From: Simon Davis
Sent: 02 December 2019 16:58
To: Richard Dollamore | Whaleback [REDACTED]
[REDACTED]
Subject: RE: Inglenook P/58/19/PL

Visibility Splays and Internal Swept Path Analysis

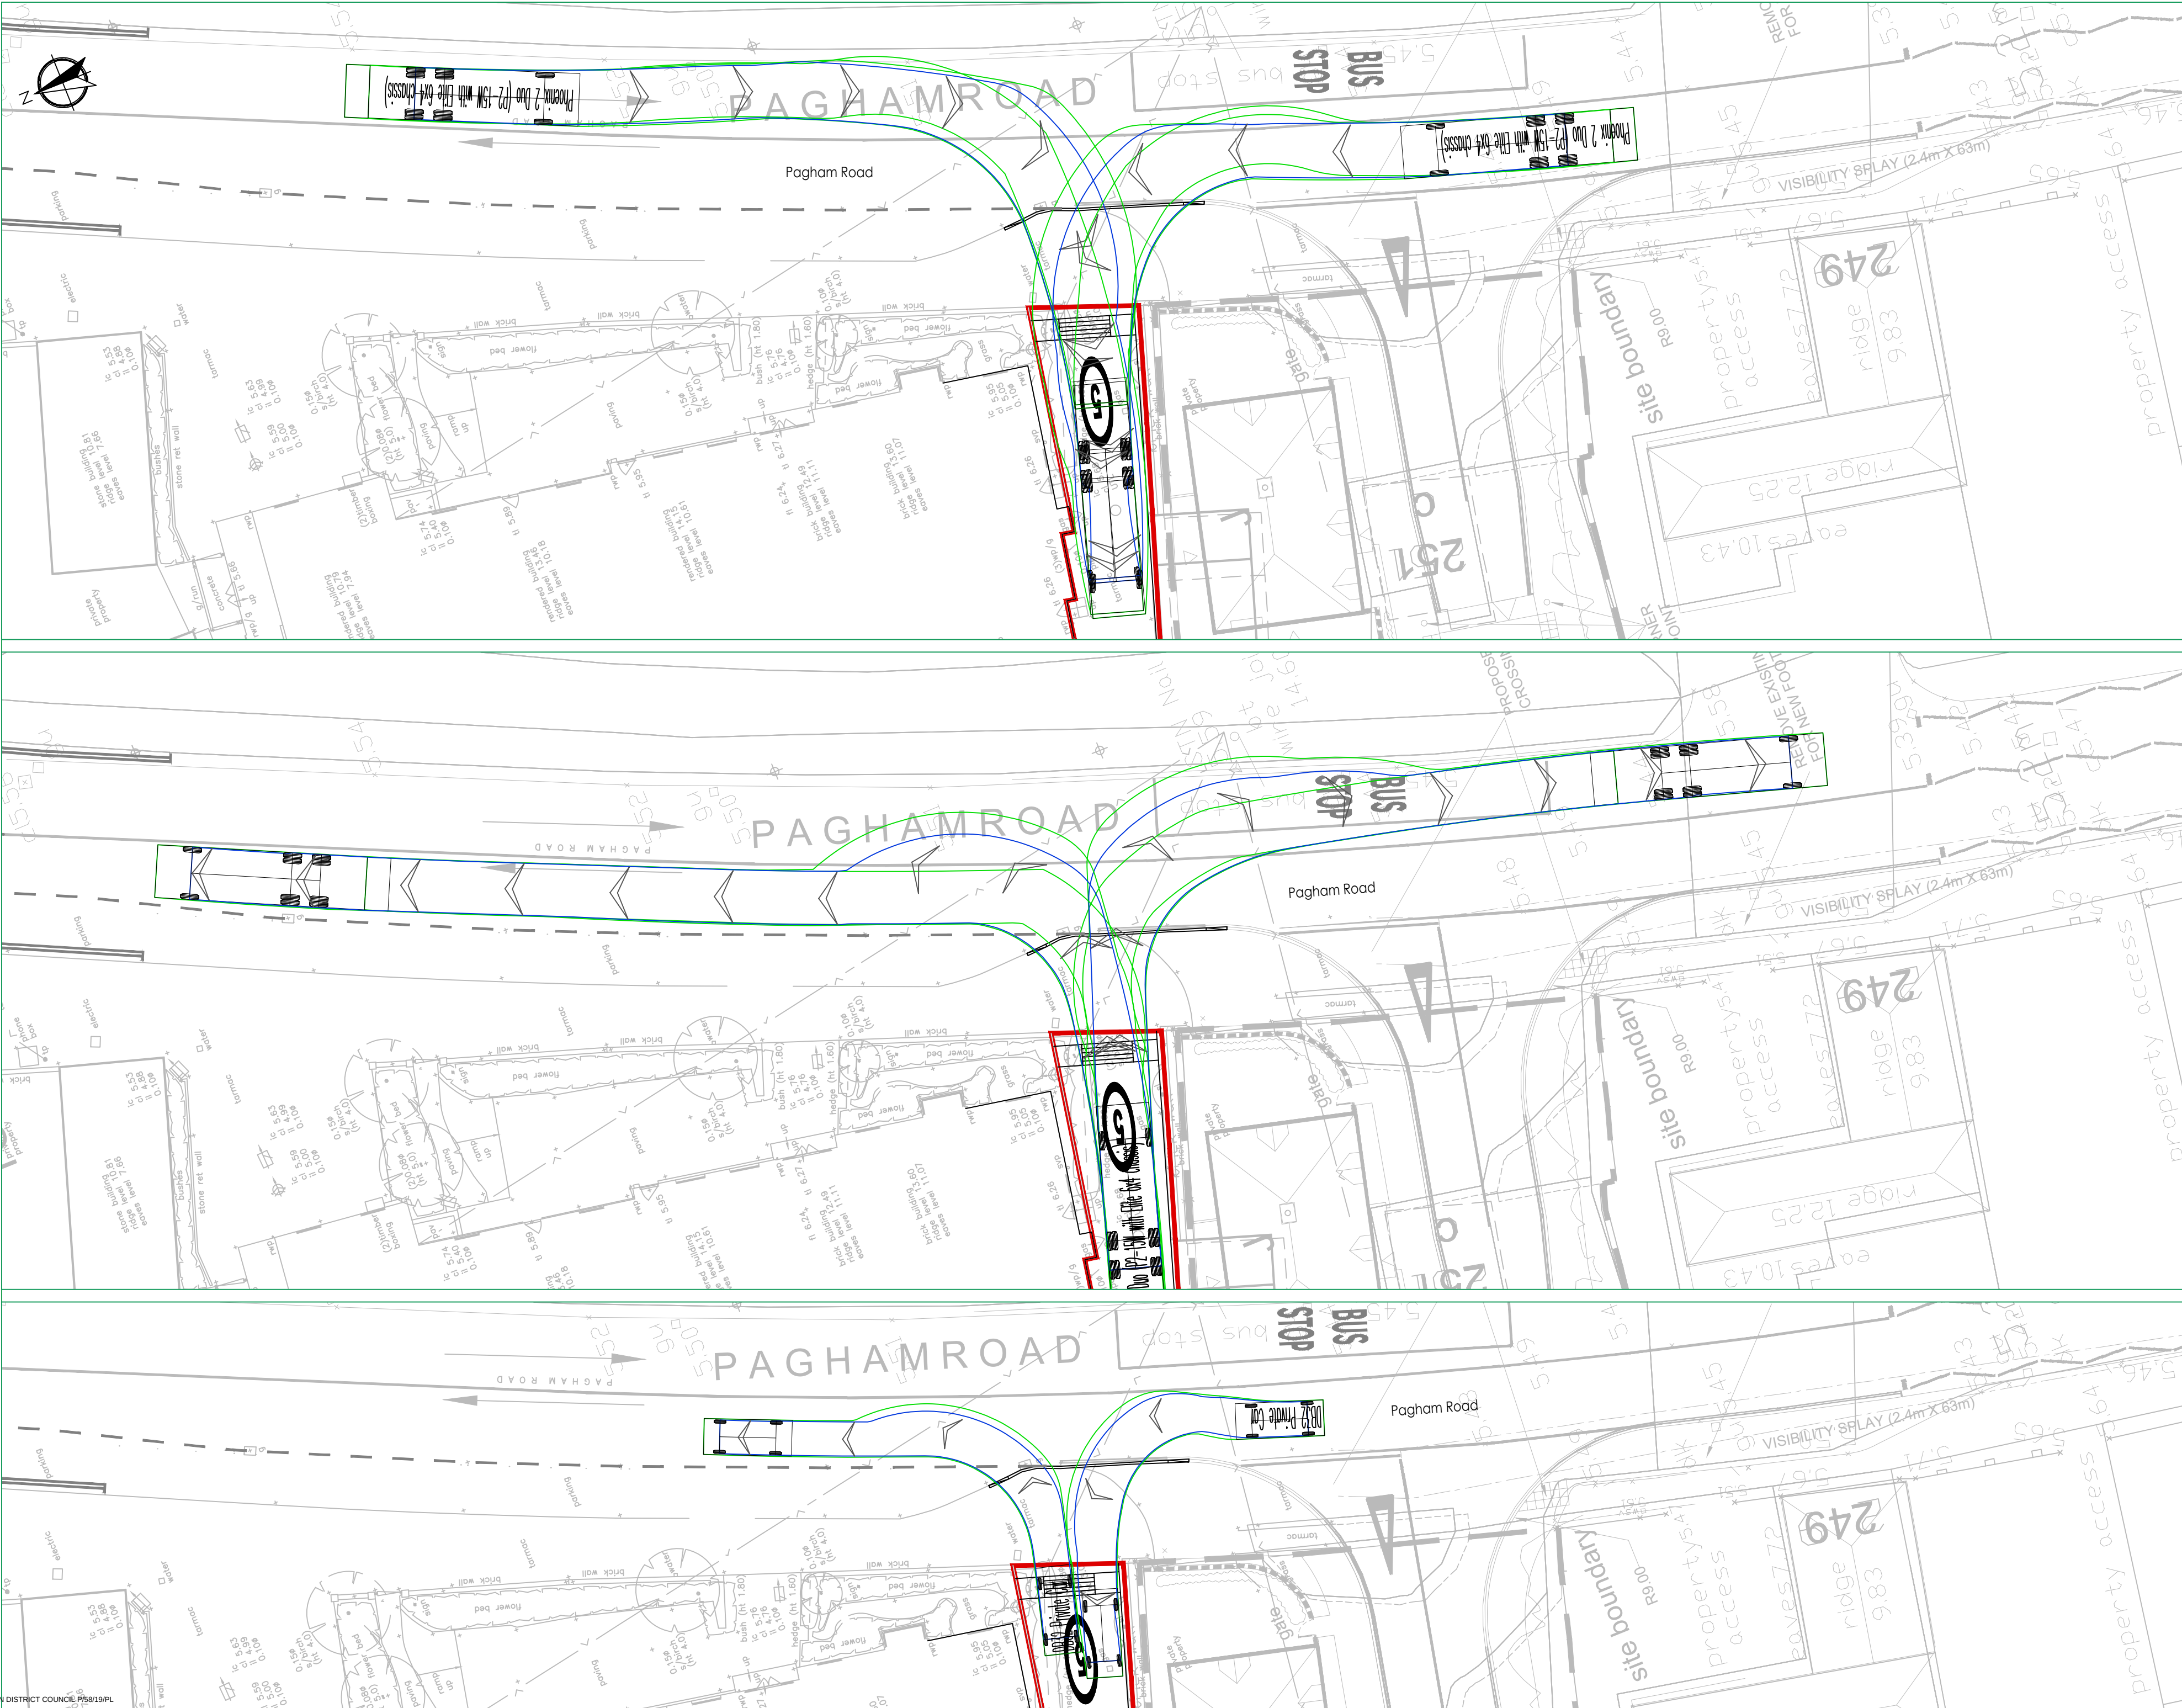
- (1) Need for a sign to advise vehicles entering the access from Pagham Road to expect pedestrians etc in the road.
- (2) Pruning/removal of trees on the inside of the left hand turn near the existing car park entrance (see top para on 2nd page of WSCC response).
- (3) Changing the surfacing of the access roads to enable travel over by wheelchairs/elderly/infirm.

I see that you have addressed (1) and (3) but it is not clear whether you have addressed point (2).

Can you also indicate on the drawing what the pavement shown on the shared drive will be constructed from. I do note though that we could secure details of surfacing through a condition.

Can you also advise why there appears to be differences between the red edge on the location plan and the red edge drawn on this plan.

With regards to your questions, we can confirm that the understorey vegetation around the trees will be removed and any side shoots or whippy growth coming from the sweet chestnuts kept trimmed to maximise visibility. There is a mixed Leyland and Lawson cypress hedge that extends to this corner; it is not very attractive and not locally characteristic. If your tree officer is in agreement, a section of this could be removed from the corner area to further improve visibility.

The pavement on the shared drive may also be surfaced in bonded gravel but will be distinguishable from the main carriageway through 3 courses of brick pavers or a dished clay channel. There is also potential for the pavement area to be surfaced in clay paviors but this would need to be considered further at detailed design stage. The line of the pavement area is indicated on the drawing. As the detail of this has not yet been agreed we would be pleased if it could be agreed by condition.
